**RE: Bradley Heights PUD Development Plan – Initial Review Comments  
File # AR PUD 21-00206**

The proposed project involves a PUD development plan to enable development of a vacant parcel into 168 single-family residences. Staff finds that the application is largely acceptable; however, the following technical modifications must be completed.

**CUSTOM COLLECTOR -
BRADLEY LANDING BLVD.**
NOT TO SCALE

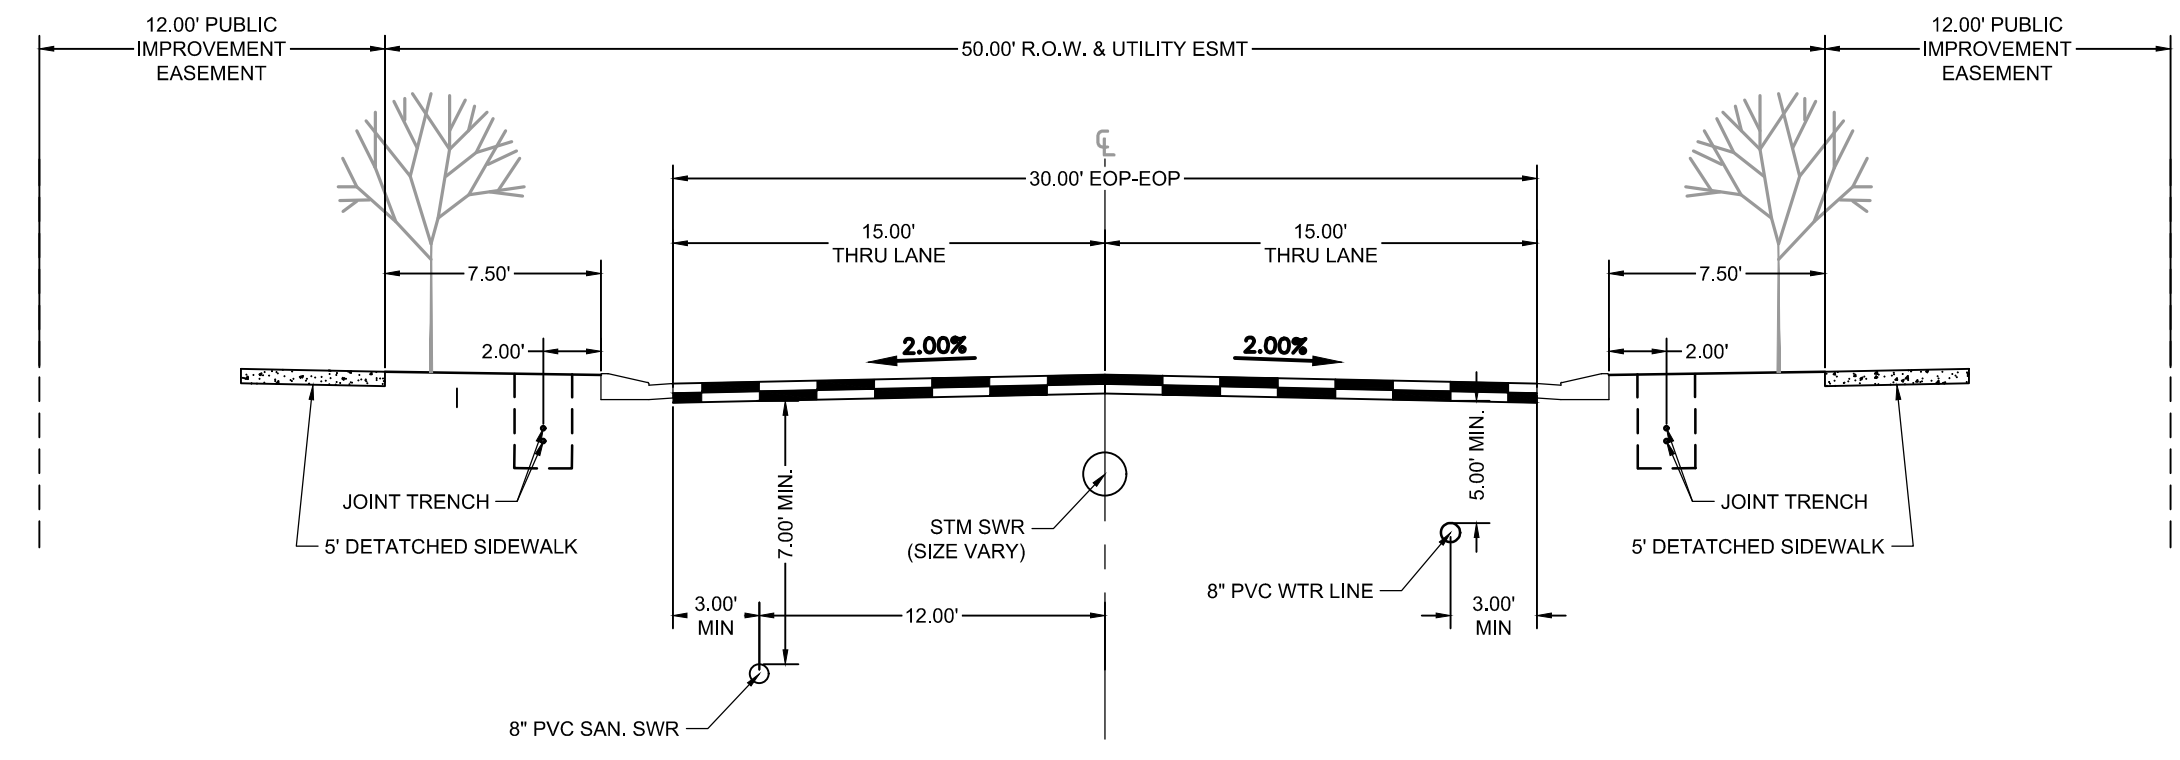
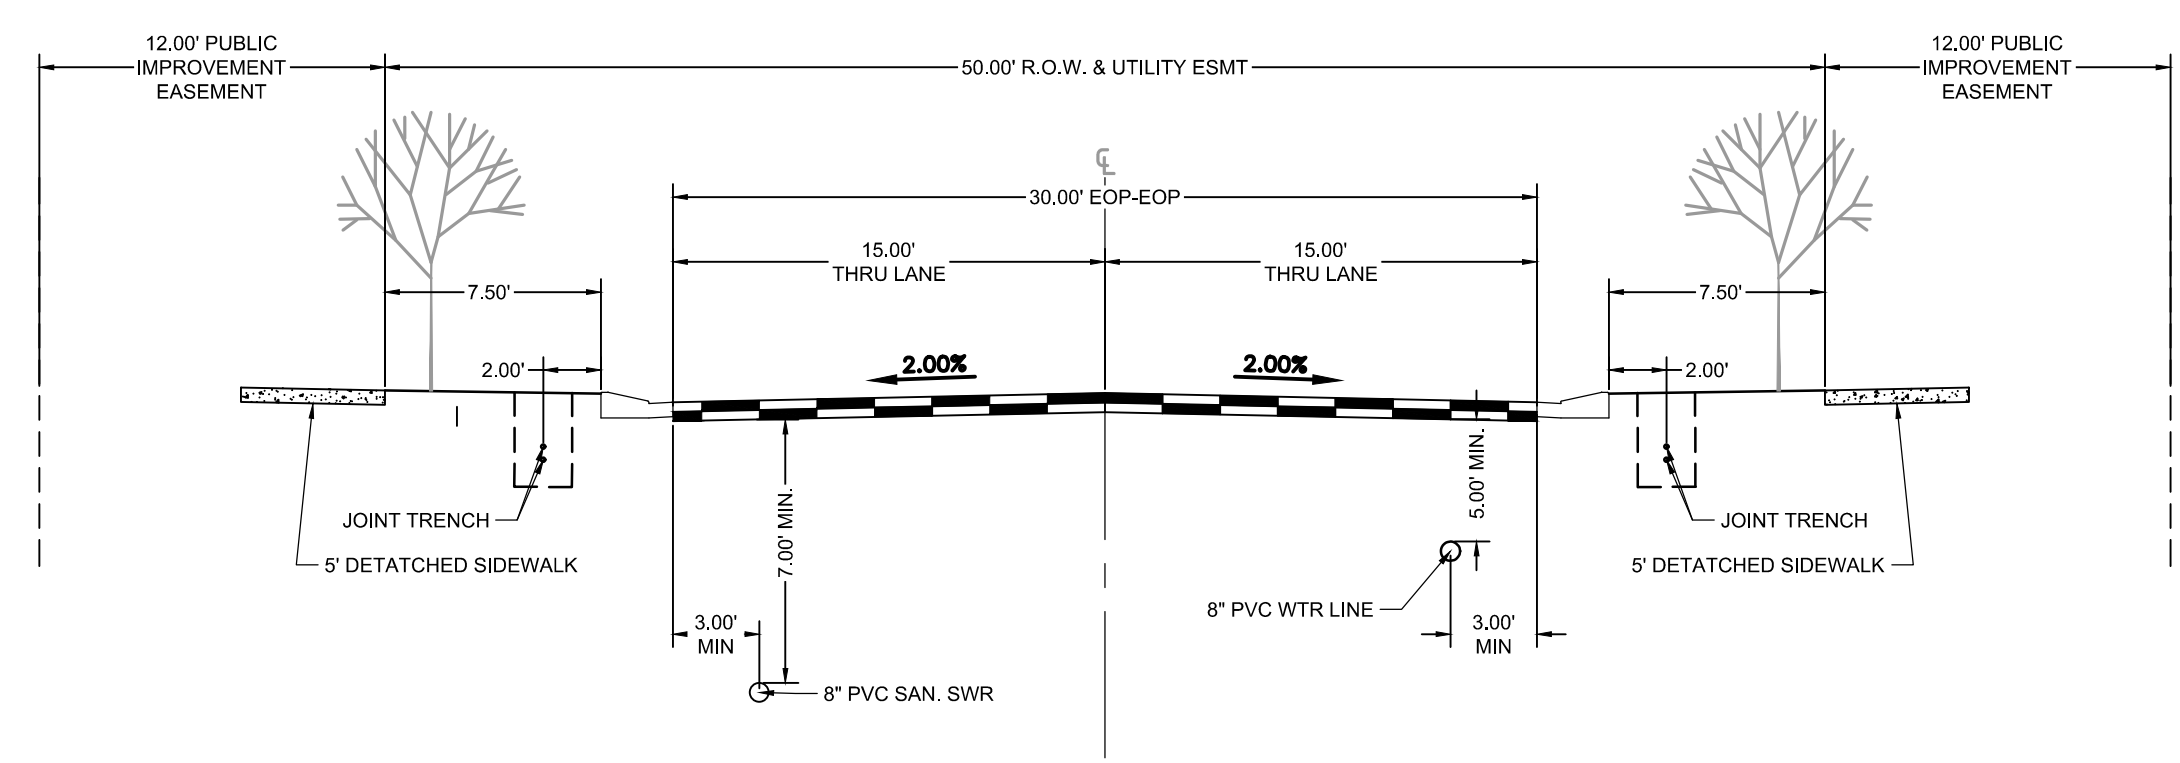
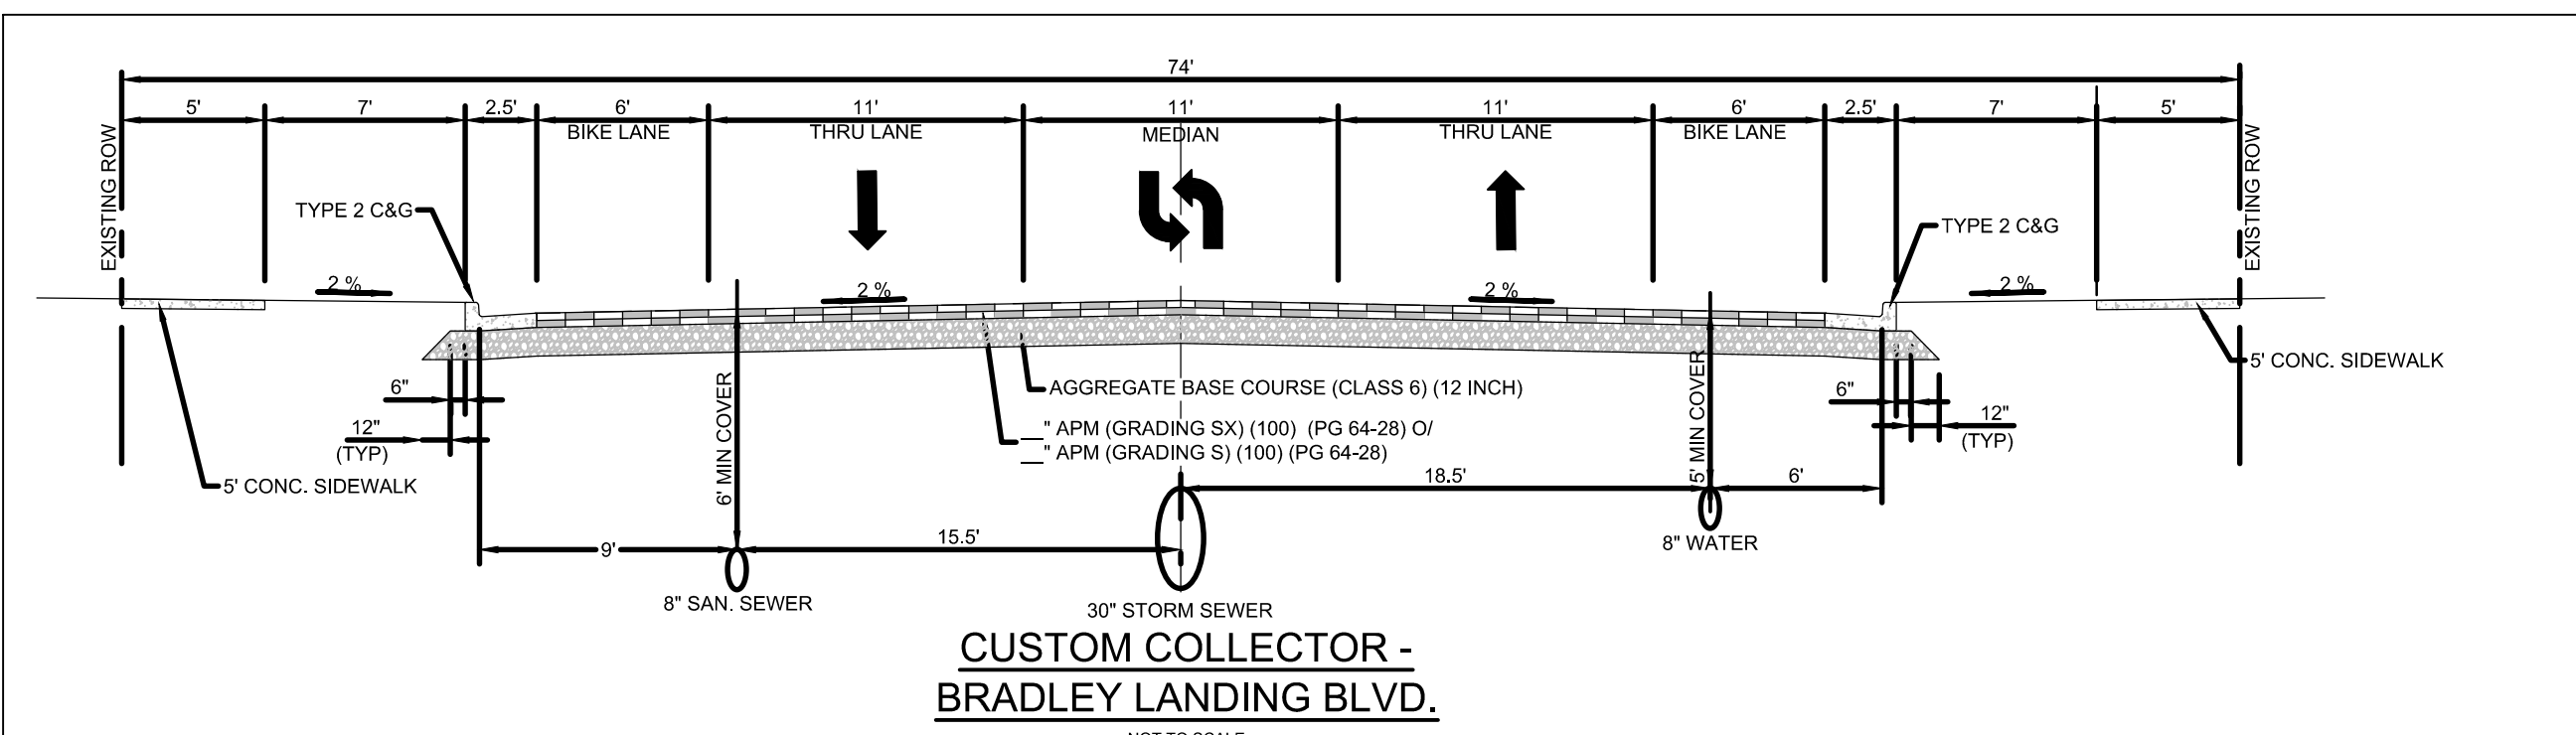
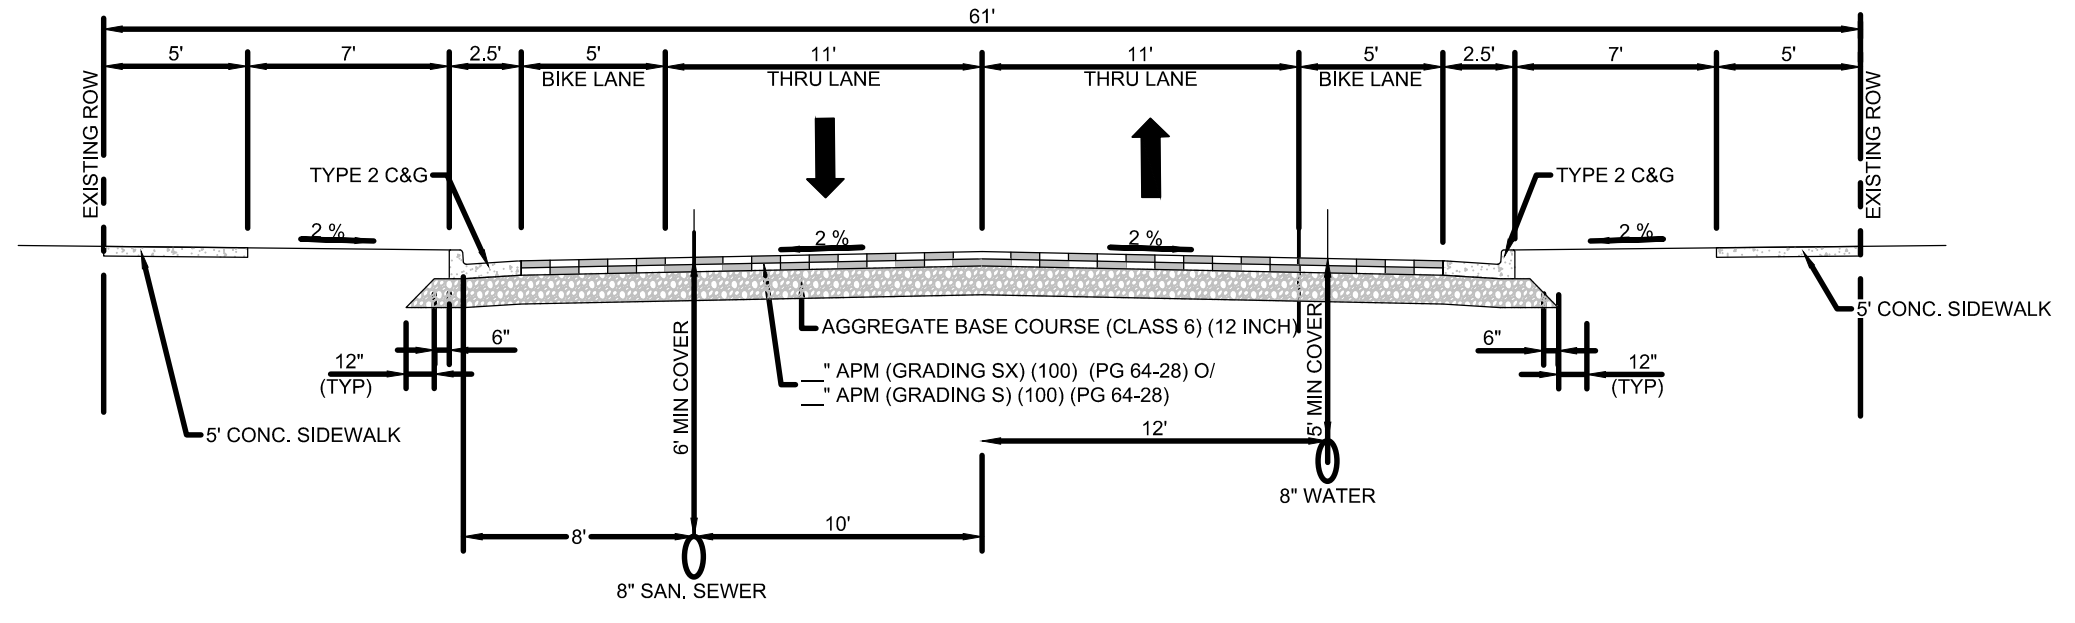
2. On Sheet 2, the residential and collector cross-sections. The joint gas and electric trench is now under the sidewalk. Update the cross-sections. Typical street cross-sections can be found in City Engineering's standard details. Include a cross-section for the Bradley Landing Blvd (Minor Arterial).

CHALLENGER HOMES
 PUD DEVELOPMENT PLAN
 OVERALL SITE DISTANCE & PHASING PLAN
 SHEET **OV** 4

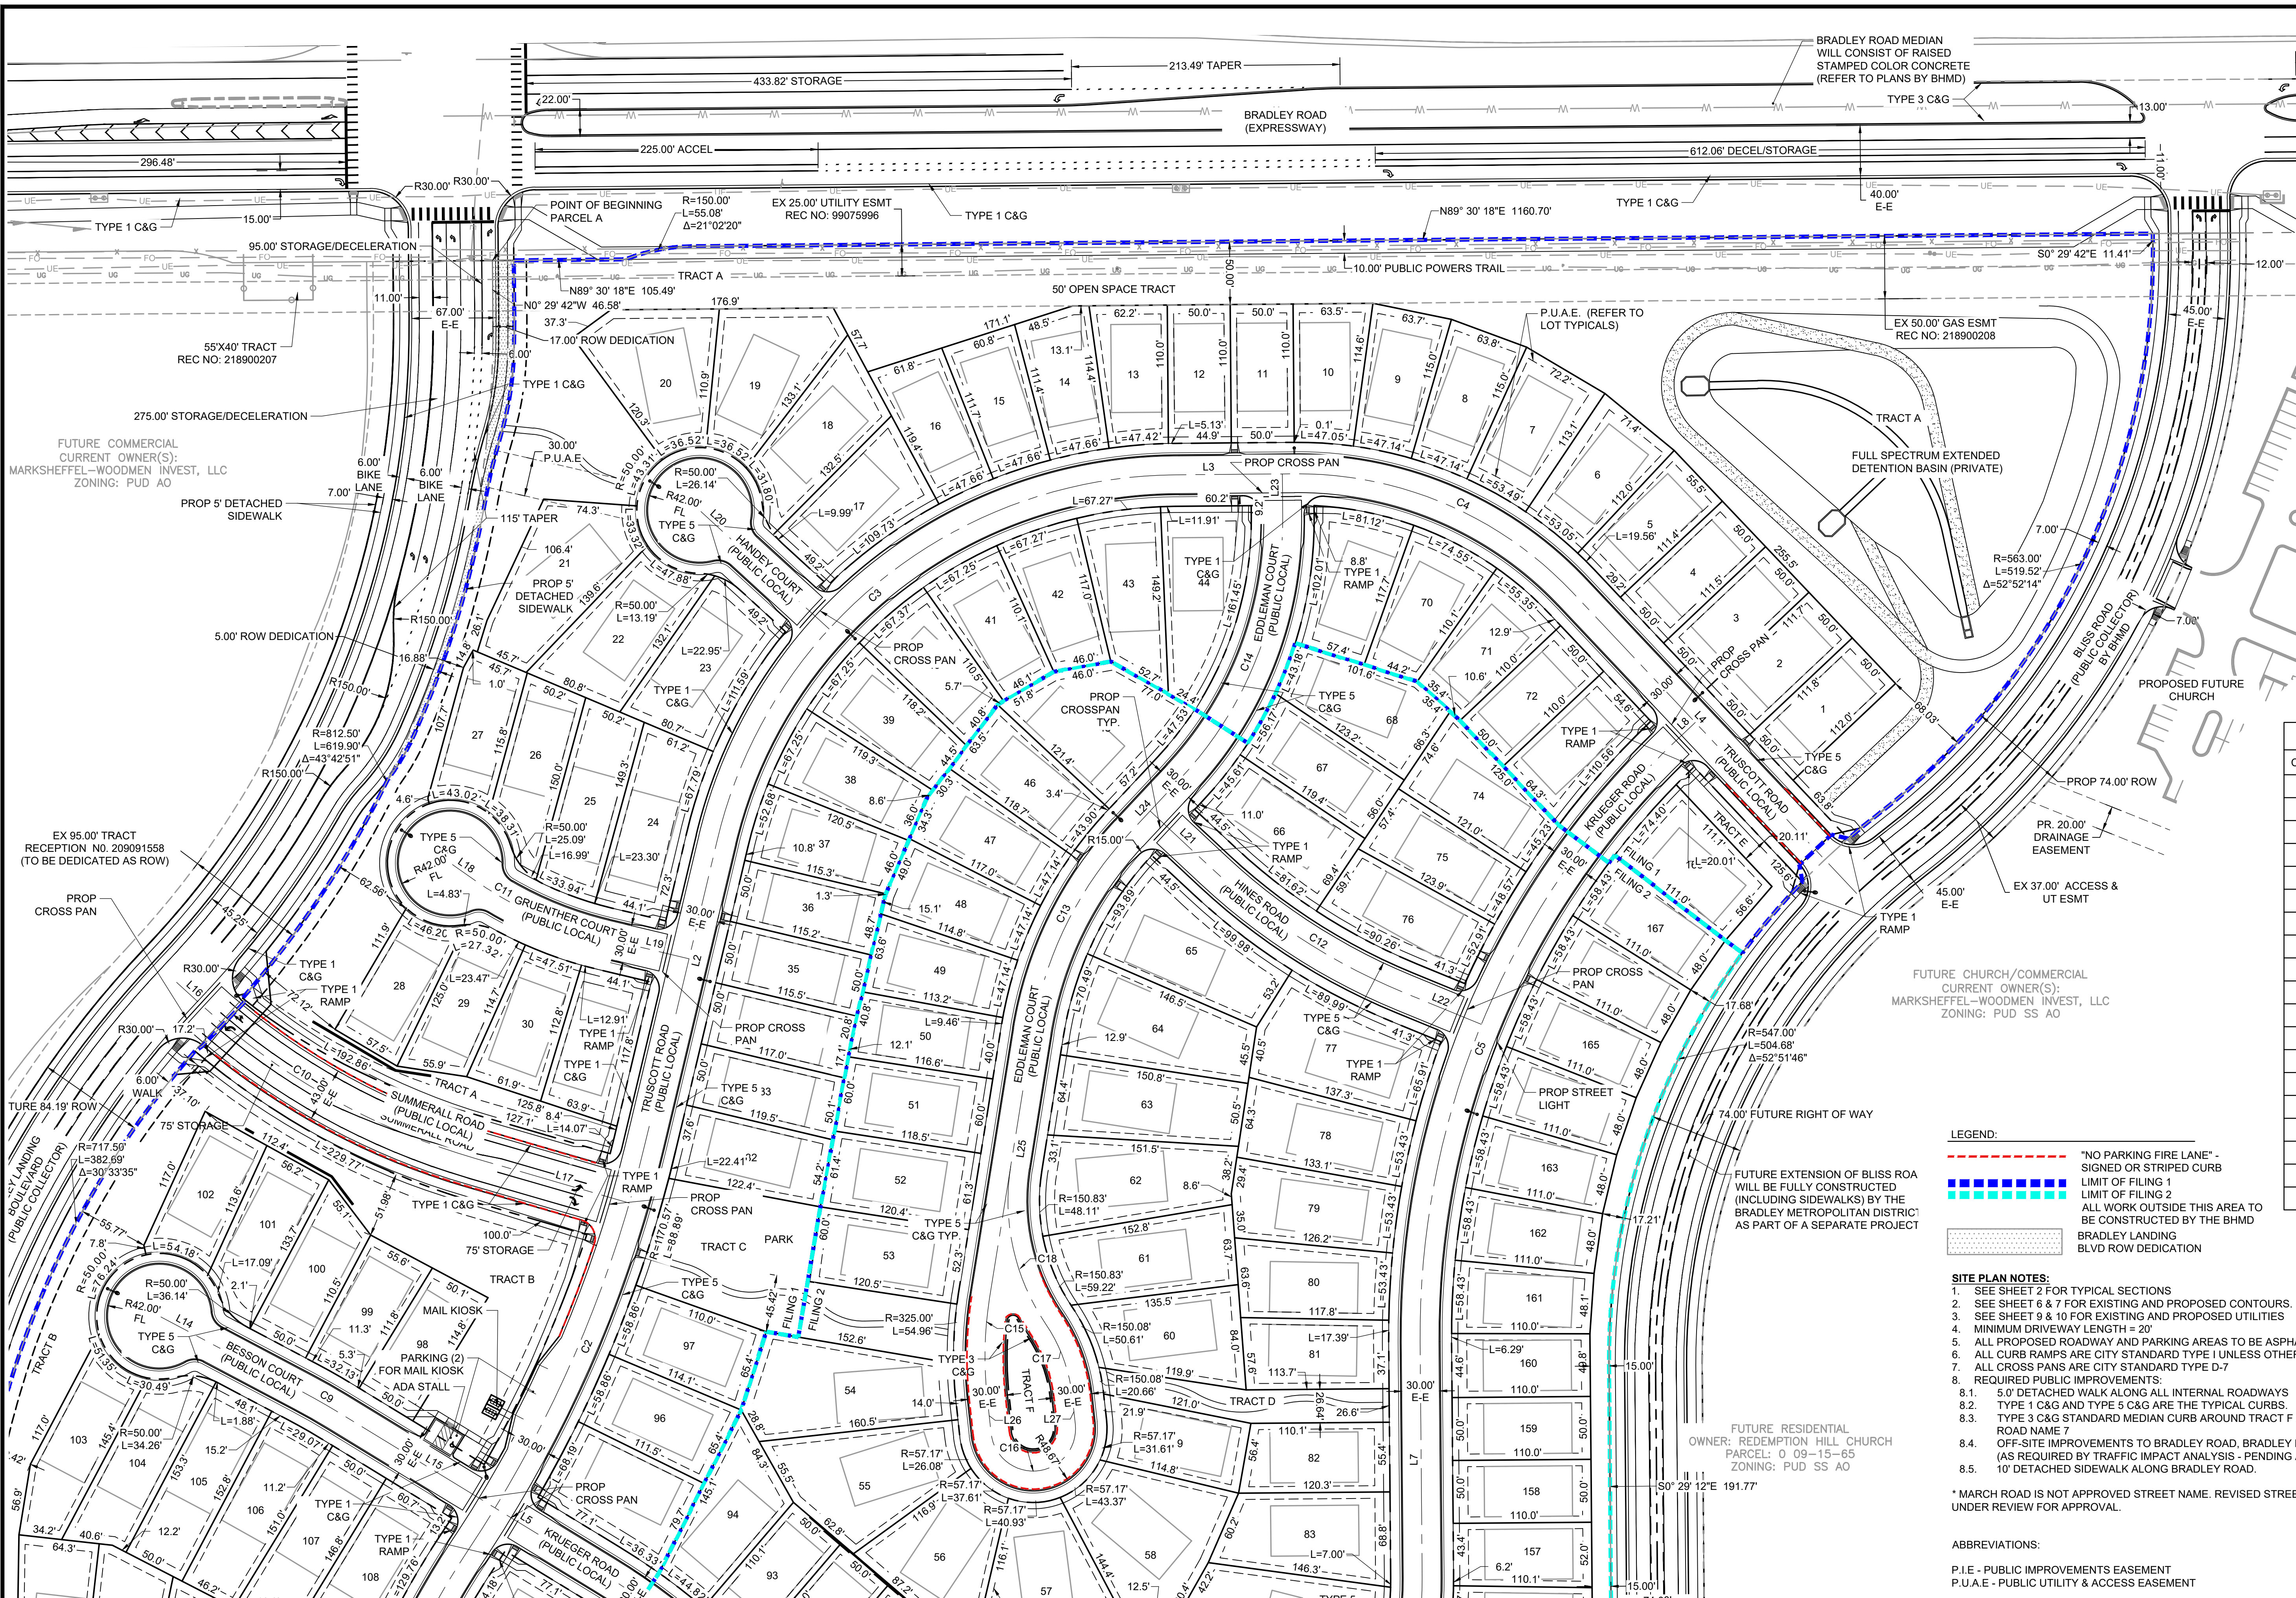
5. Remove note on sheets 4 and 5 stating minimum driveway length is 15 feet. Minimum must be 20 feet.
6. Confirm whether any retaining walls are to be utilized? If so, show on grading plan and denote T.O.W. and B.O.W.
